**RE: CHARTER SCHOOL SOLUTIONS, ALBUQUERUQUE SCHOOL OF EXCELLENCE
13201 LOMAS BLVD NE
TRAFFIC CIRCULATION LAYOUT
SUBMITTED JULY 7, 2020
ENGINEER'S STAMP 11/12/18 (K22Z)**

Below is our response to comments based on the referenced job above:

ABQ SCHOOL OF EXCELLENCE ADMINISTRATIVE AMENDMENT TRAFFIC CIRCULATION LAYOUT	DRAWN BY pm DATE 7-20-2020 DRAWING 2019068-SP SHEET # SP-1
	ENGINEER'S SEAL RONALD R. BOHANNAN P.E. #7868 7-20-2020	TIERRA WEST, LLC 5571 MIDWAY PARK PL NE ALBUQUERQUE, NEW MEXICO 87109 (505) 858-3100 www.tierrawestllc.com

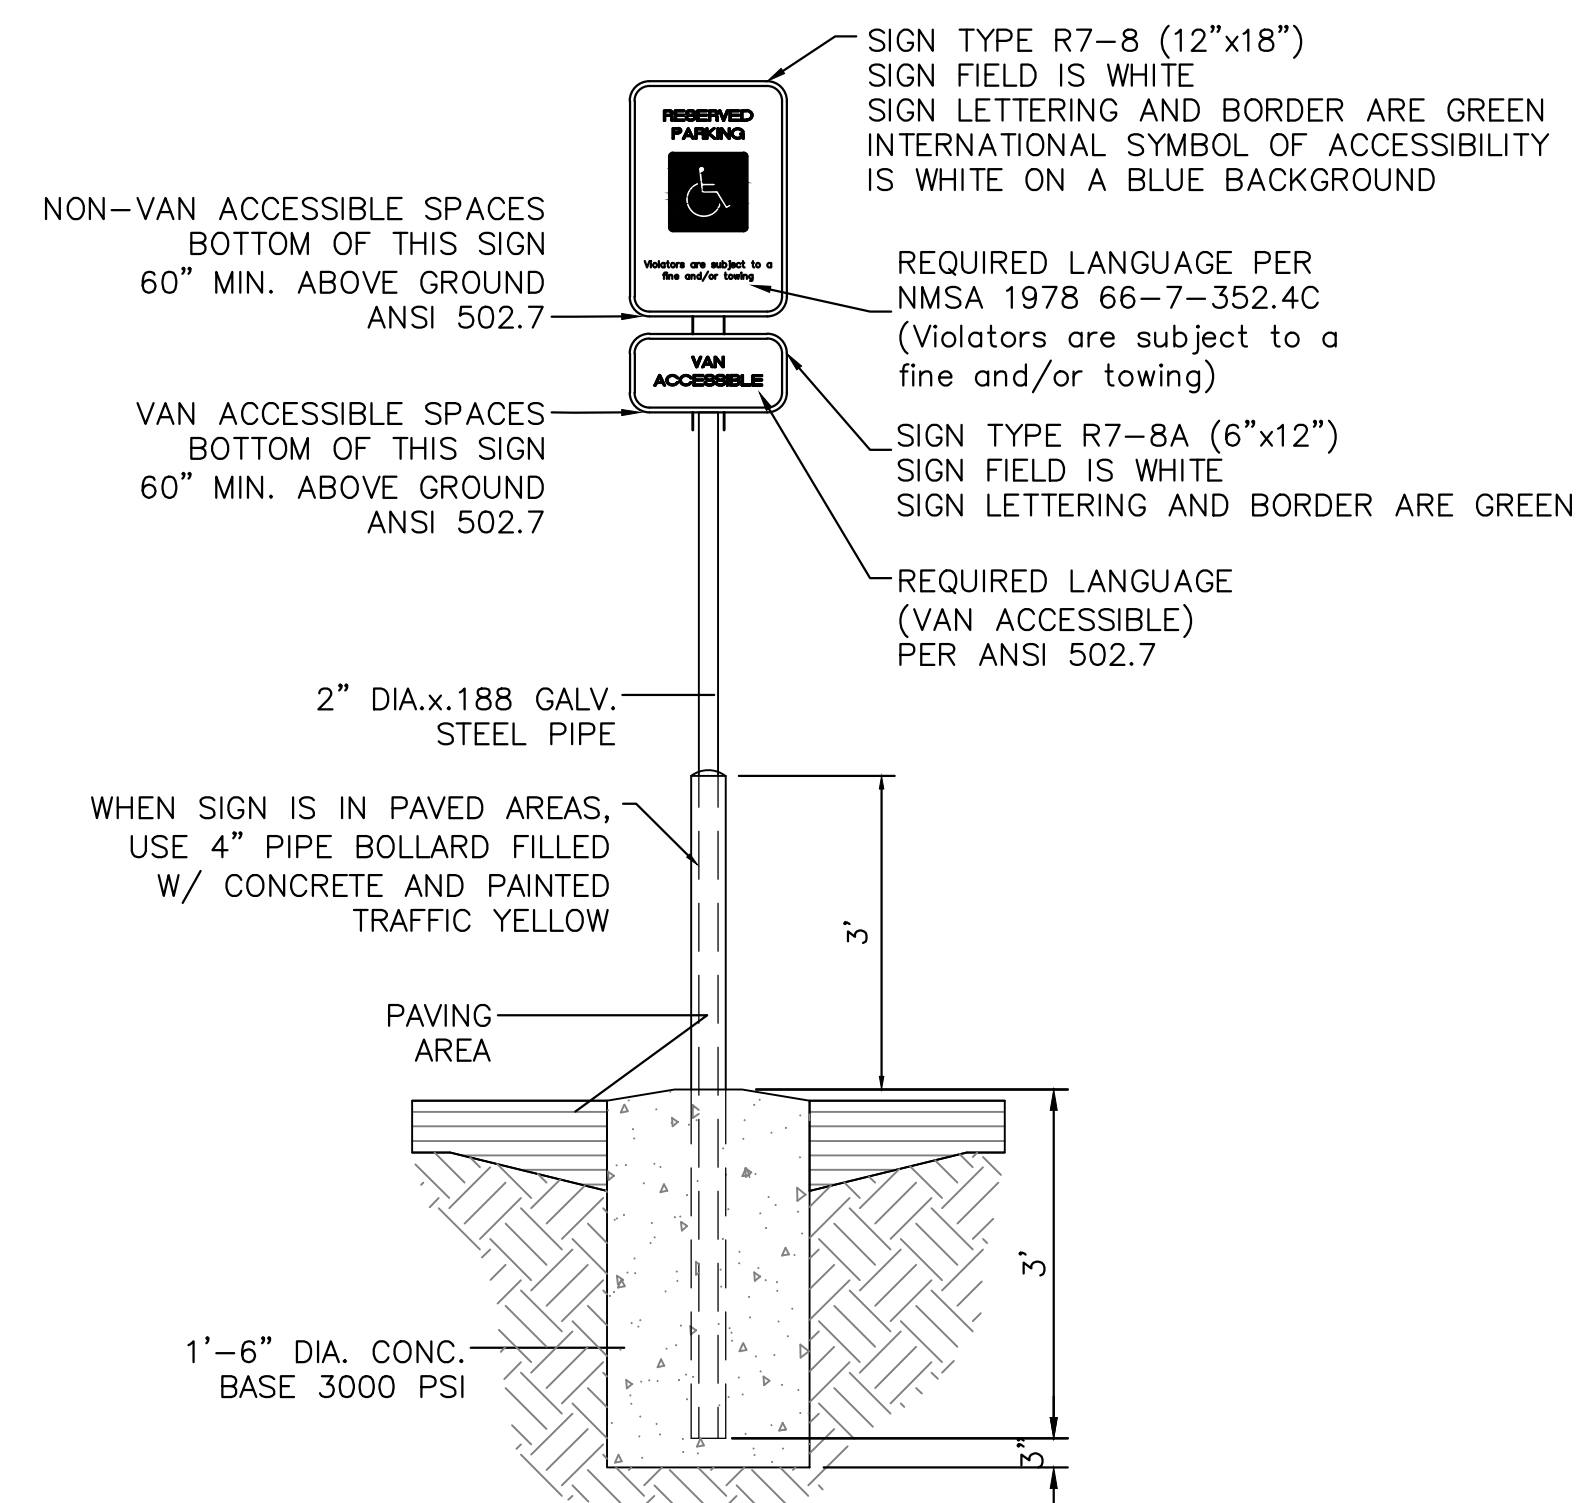
3. Place ADA tactile warning surfaces on existing sidewalk ramps where missing each side of driveway on Lomas Blvd. Revise keyed note 11 to include the tactile surface for ramps.
The tactile warning surfaces are now called out on the plan.

4. Label compact parking spaces by marking "Compact".
The compact parking spaces are labeled with the word Compact and a striping detail is now included on the plans.

5. Five-foot keyway required for dead-end parking aisles. One space in the far NE corner is against the retaining wall. This space needs a keyway.
The last space was converted to a landscape island to provide the five-foot keyway.

6. One-way vehicular paths require directional signage/posted "Do Not Enter" sign for all one-way paths.
That drive aisle now has signs and directional striping.

7. Fire and emergency access by fire and emergency vehicles needs to be in accordance with the Albuquerque Fire Plan Checking Division. No fire or emergency accommodations shown on plans.
The fire hydrants are called out on the plan along with the FDC for each building. Fire lane striping was also added to the plan.

8. Plans show 3.06% slope near the ADA parking. Cross-slope in the ADA parking will exceed the allowable 2% cross-slope.
The 3.06% was for the drive aisle. The ADA spaces are at a 1.80% slope and do not exceed a 2.0% slope.

9. Landscape planters near the ADA parking should be removed / relocated. The planters interfere with the crosswalks / ramps and constrict the sidewalk near the ADA parking spots. **The tree wells were either adjusted or removed to provide a clear path for the ADA ramps.**

LANDSCAPE PLAN

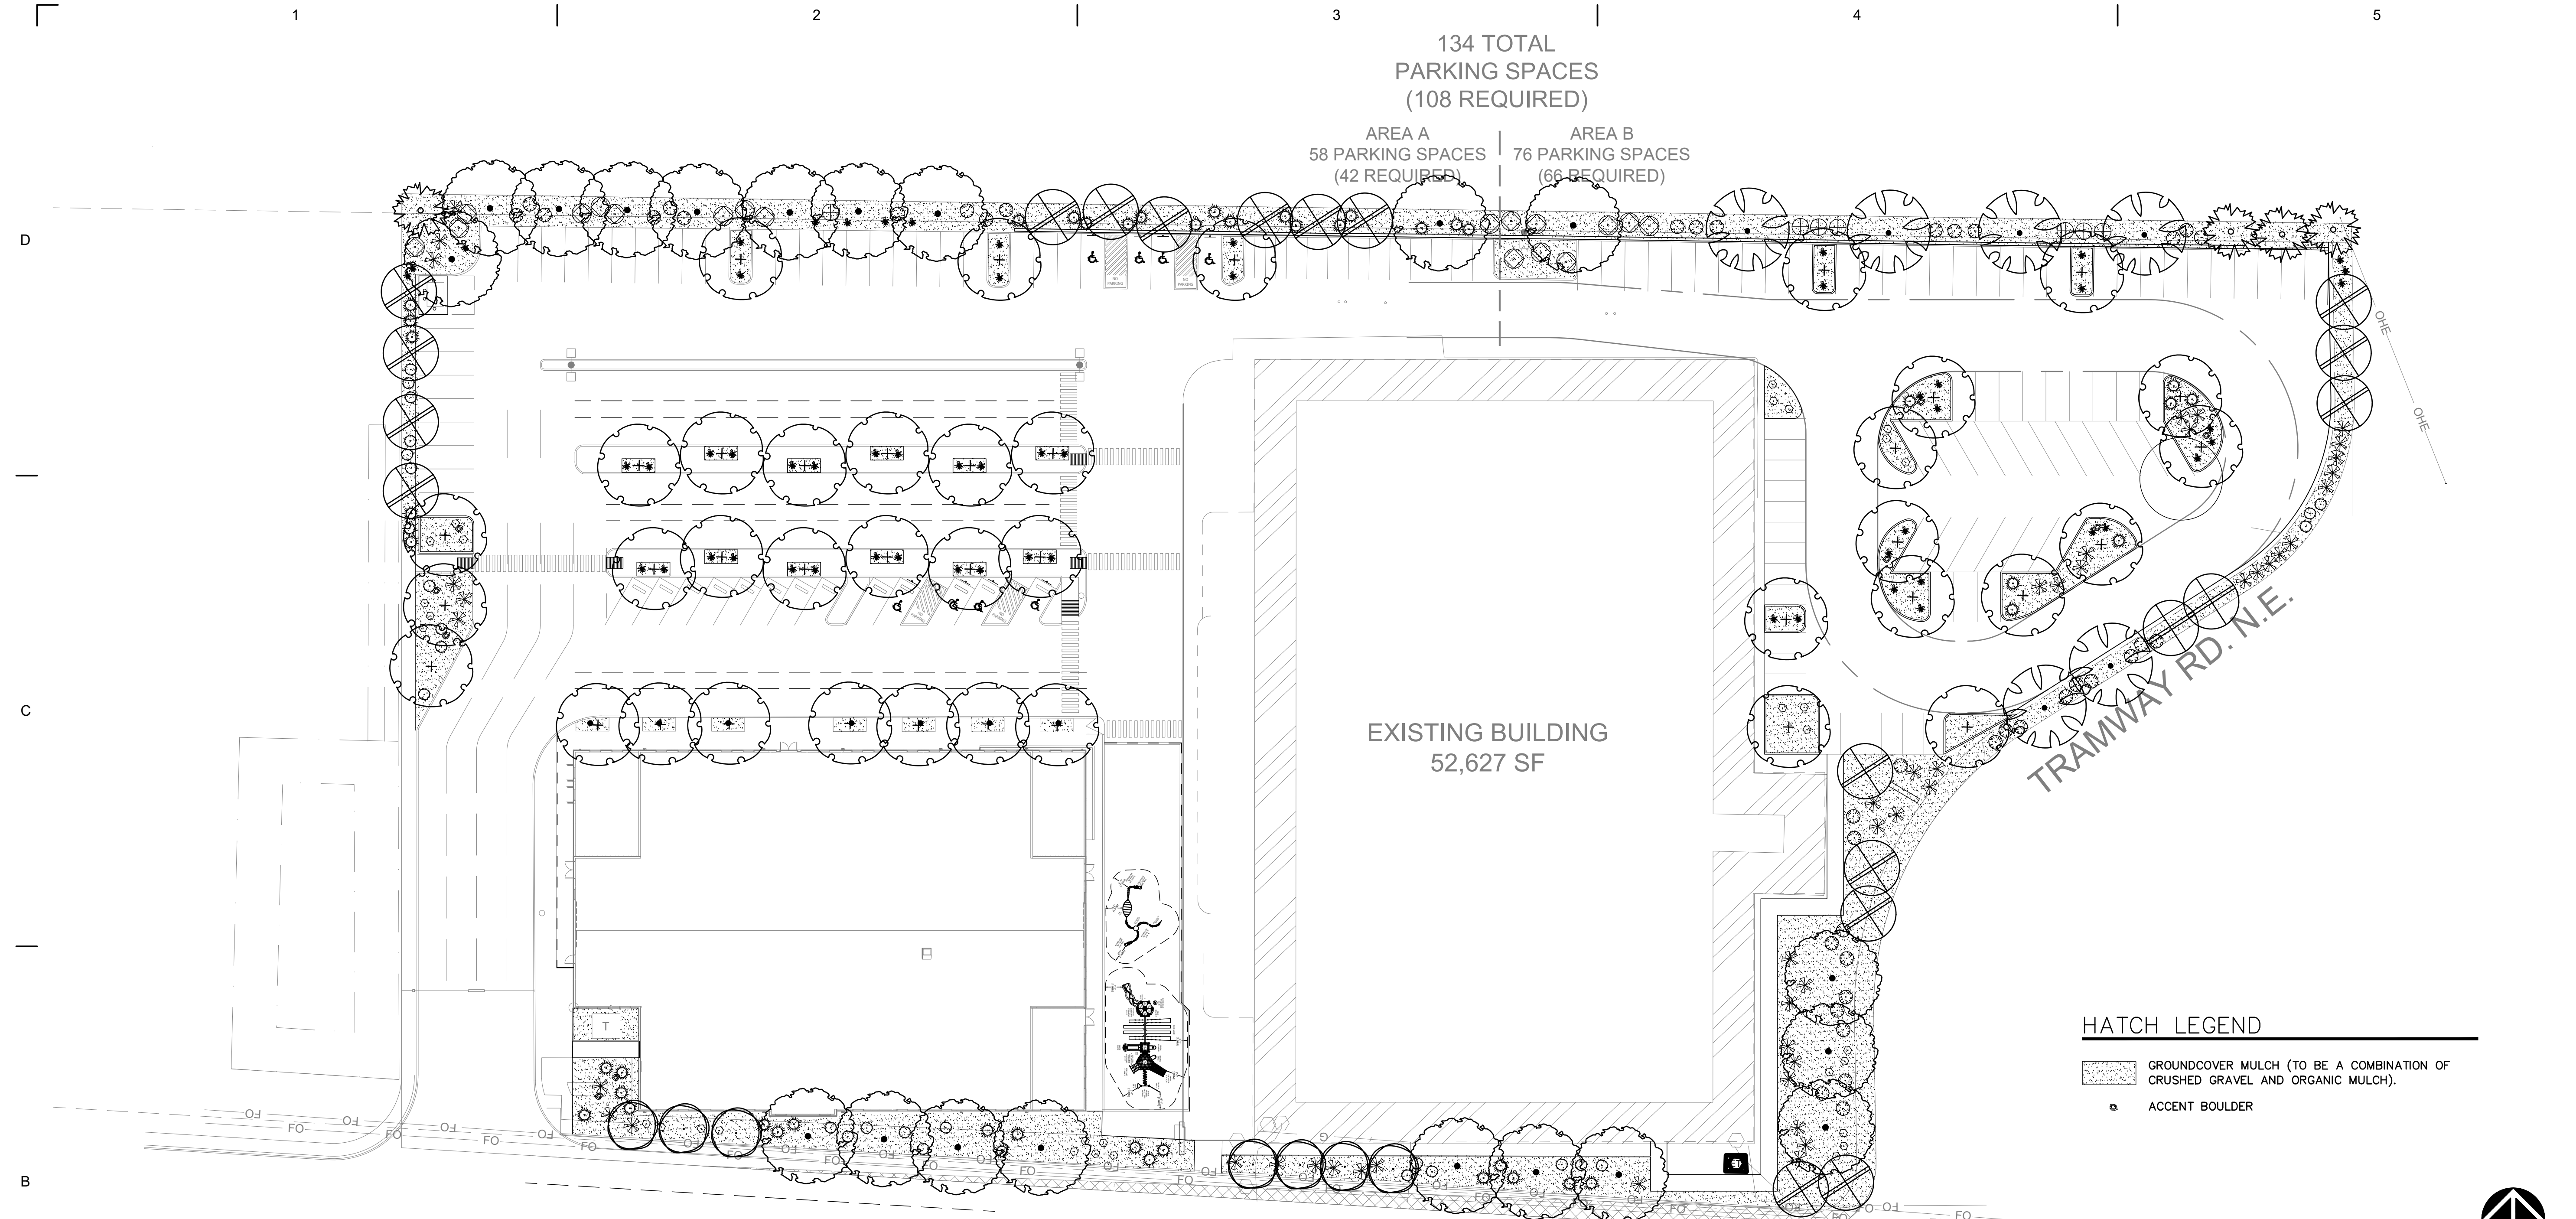
2. Plan must be stamped, signed, and dated by the P.E. or R.A. Architects seal and signature are missing from the landscape plans.
The Landscape Plans now have a seal and signature by the landscape architect
